OBJECTION to Application No. SSD-78996460
16-24 LORD STREET and 21-27 ROSEVILLE AVENUE, ROSEVILLE
Residential Development with In-fill affordable housing

I am writing to formally object to the above Application (the **proposed development**).

1 EAST ELEVATION (MARTIN LANE)
SCALE 1:250

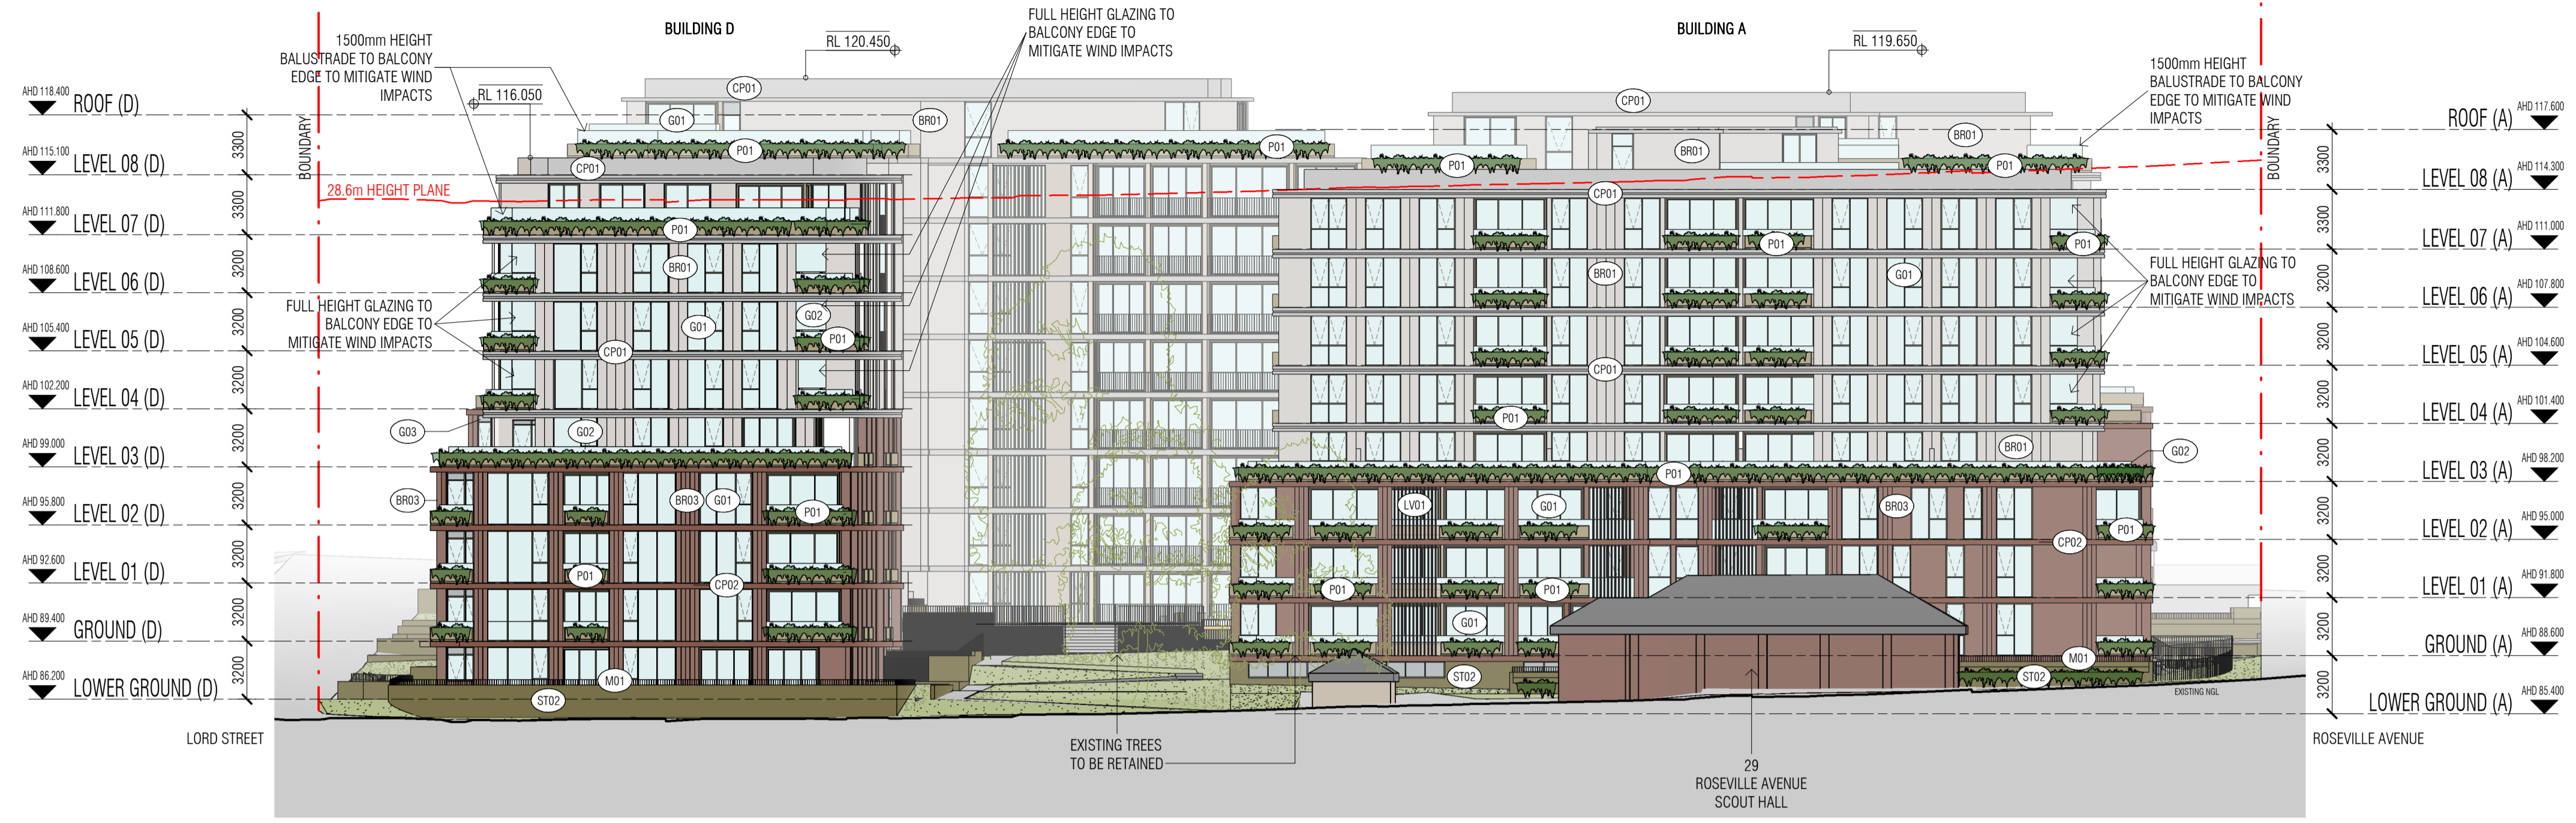
The second ground for my objection is that the proposed development is materially non-compliant with the ADG building separation controls. This would have huge deleterious impacts on the western neighbours at 19 Roseville Avenue and 14 Lord Street, both of which have been excluded from the TOD provisions and would therefore be a ‘lower density residential use’ when compared to the proposed development. Considering this, Figure 3F.5 of

the ADG applies and requires an additional setback of 3m (or more) to the western boundary (see **Figure A** below).

The proposed development does not comply with this requirement and does not offer any justification.

This non-compliance is contrary to Section 161 of the Housing SEPP. It also compounds the lack of a transition in scale between properties, increases bulk and scale relative to the neighbours and contributes to unreasonable shadowing and privacy impacts. Each of these matters are grounds for rejection of the Application.
